Mountain View Electric Association, Inc. (MVEA) has these comments about the following:

Project Name: Mountain's Edge Subdivision

Project Number: SF 201

Description: Approval is being requested for the Final Plat of Mountain's Edge Subdivision for five (5) residential lots on approximately 31 acres. This parcel is located northeast of McClelland Road and Scott Road in Section 13, Township 12 South, Range 63 West and is currently zoned RR-5 (Residential Rural).

MOUNTAIN'S EDGE

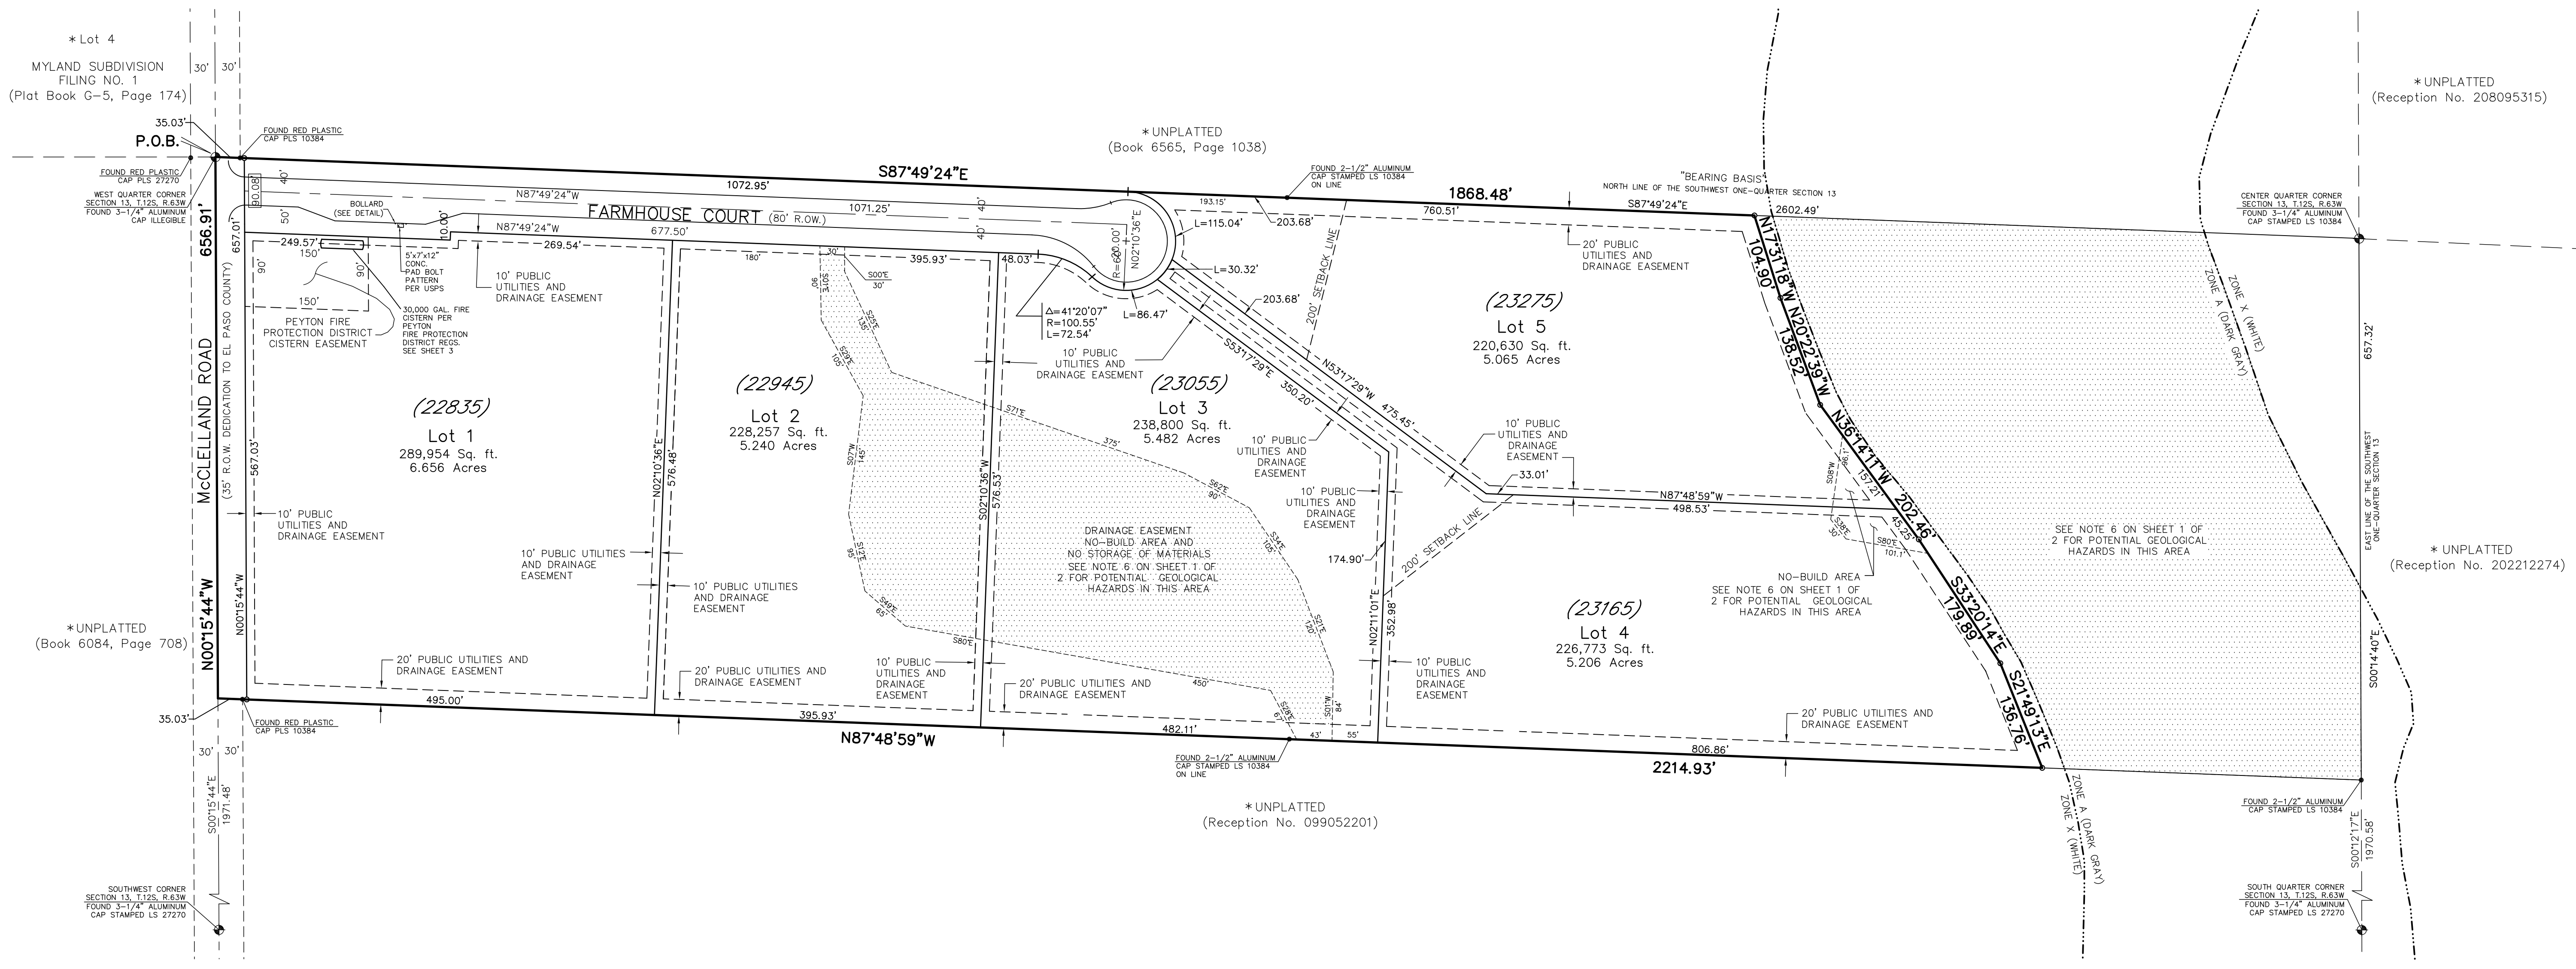
MVEA notes the utility easements shown on the final plat of ten (10) foot front, side and back lot lines along with a twenty (20) foot exterior subdivision easement. MVEA also requests platting of existing MVEA facilities with easement on the plat. Additional easements may be required once a review of civil drawings with grading and erosion plan is provided to MVEA in order to serve this subdivision.
